**Planning Department
Transportation Development Services**

July 24, 2014

**Re: LOT 7 BLK 6 SOMBRA DEL MONTE
180-Day Temporary Certificate of Occupancy- Transportation
Development**
Engineer's Stamp dated 10-25-10 (H19-D079)
Certification dated 07-15-14

LOT 7, BLOCK 6, SOMBRA DEL MONTE SITE PLAN FOR BUILDING PERMIT

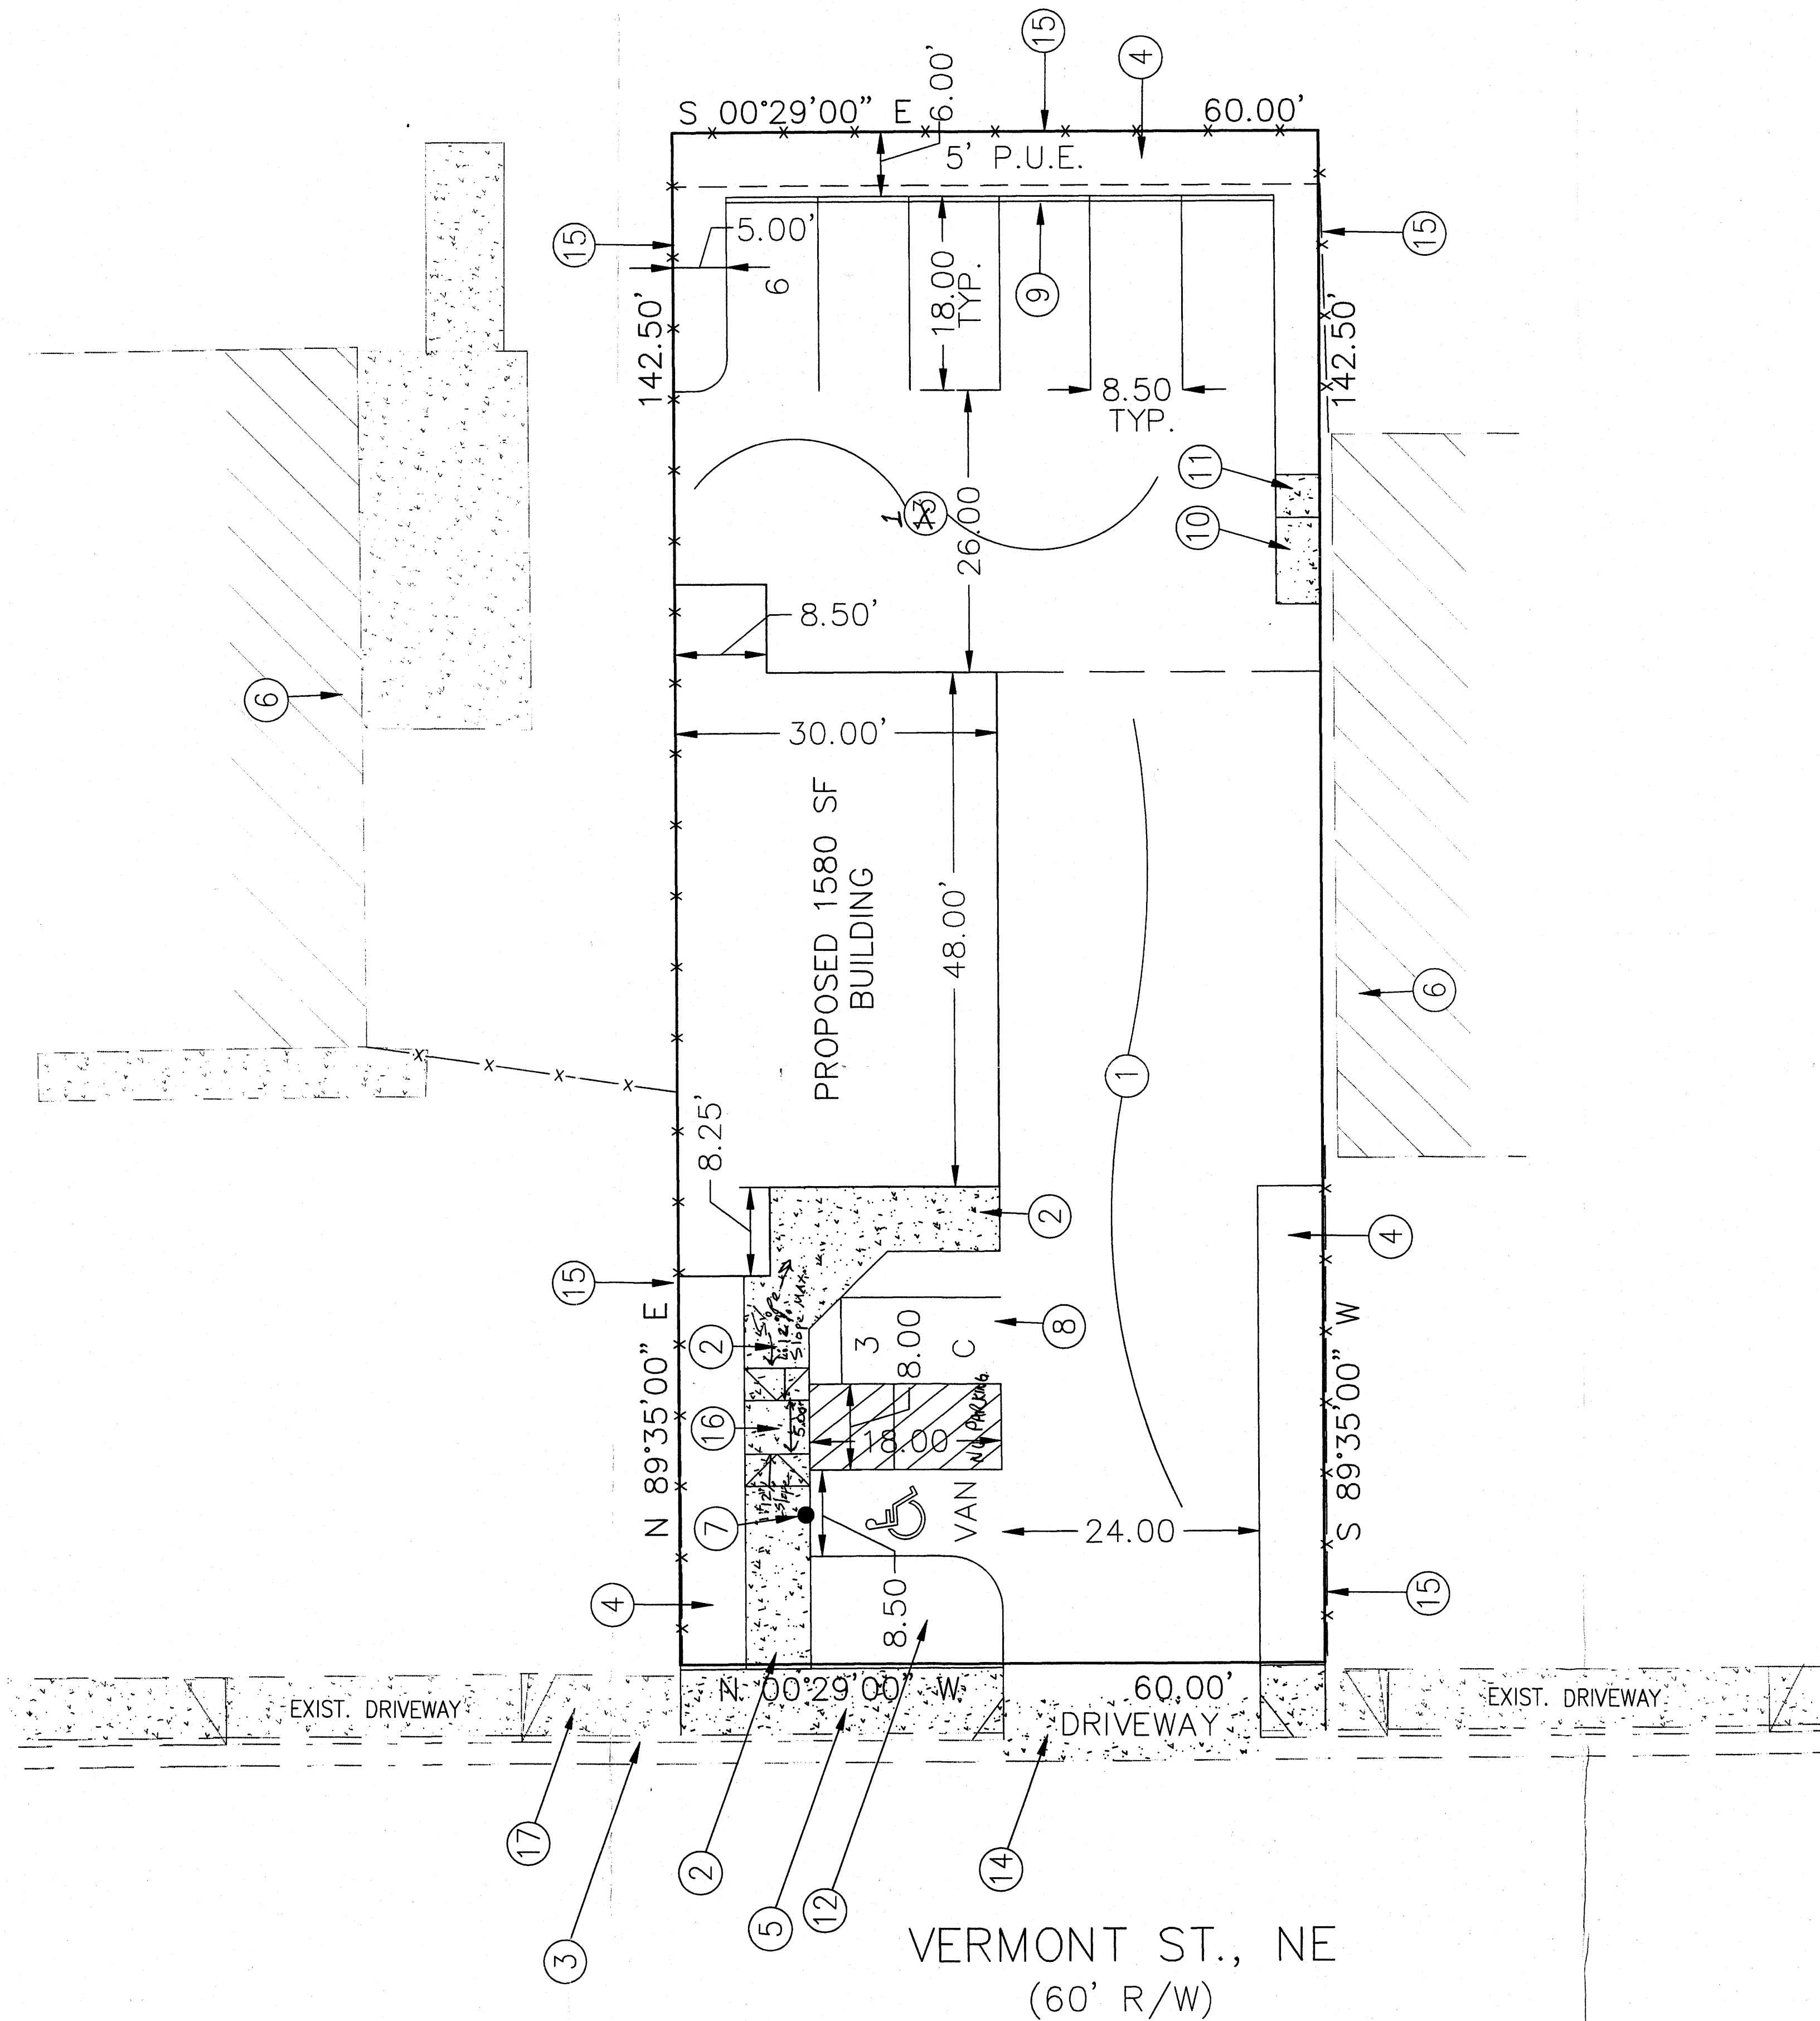
- The ADA van accessible sign must have the required language per 66-7-352.4C
NMSA 1978 "Violators are subject to a fine and/or towing."
- The ADA access aisle shall have the words "NO PARKING" in capital letters, each
of which shall be at least one foot high and at least two inches wide, placed at the
rear of the parking space so as to be close to where an adjacent vehicle's rear tire
would be placed. (66-1-4.1.B NMSA 1978)
